Our Ref: B3031

27 April 2022

#### Re: Minto Resource Recovery Facility (SSD-5339) 23 February 2022 - Request for additional Information

EARTHWORKS CUT & FILL ANALYSIS PLAN

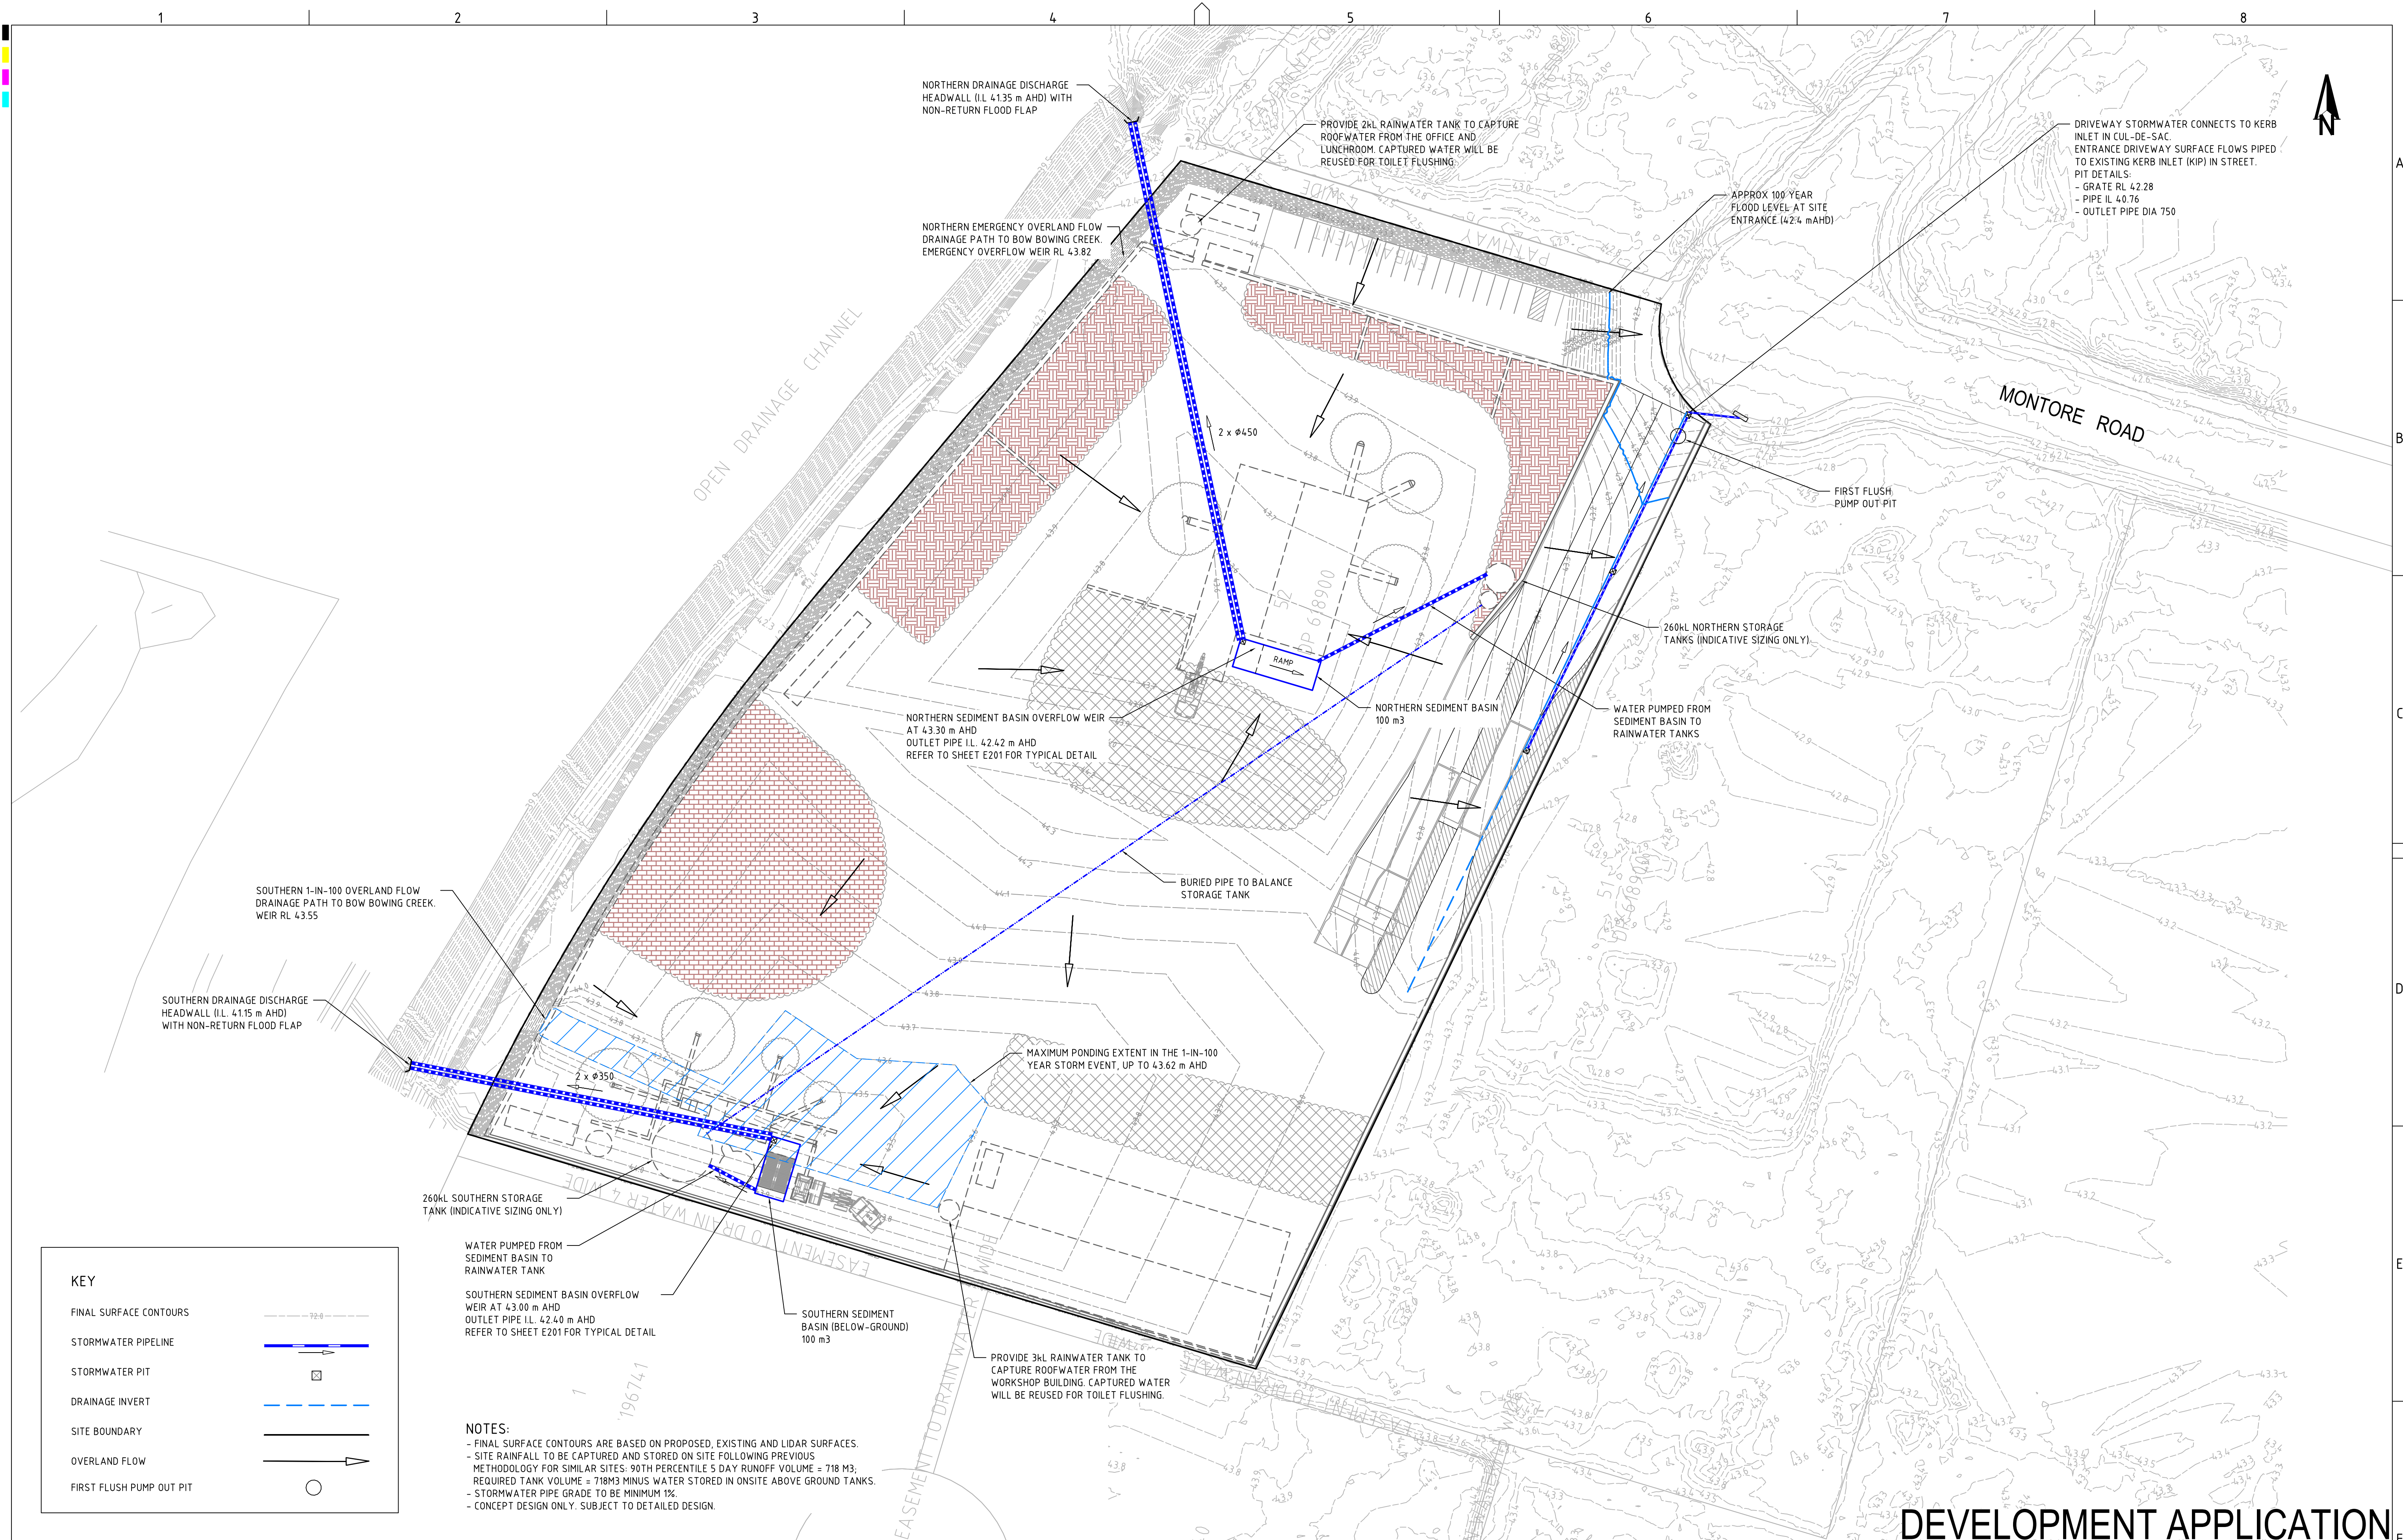
Changes to the development made since exhibition of the EIS have still not been clearly articulated. Please list all changes made to the development, noting that a description of changes made to plans is not required. Changes should include the amendment to cut and fill and boundary fence, amendments to the stormwater system, additional length of noise wall, additional bunker walls etc.

There is no change to the cut and fill quantities as a result of the proposed changes to the development - refer to Plans PS02-C600, Revisions G and I.
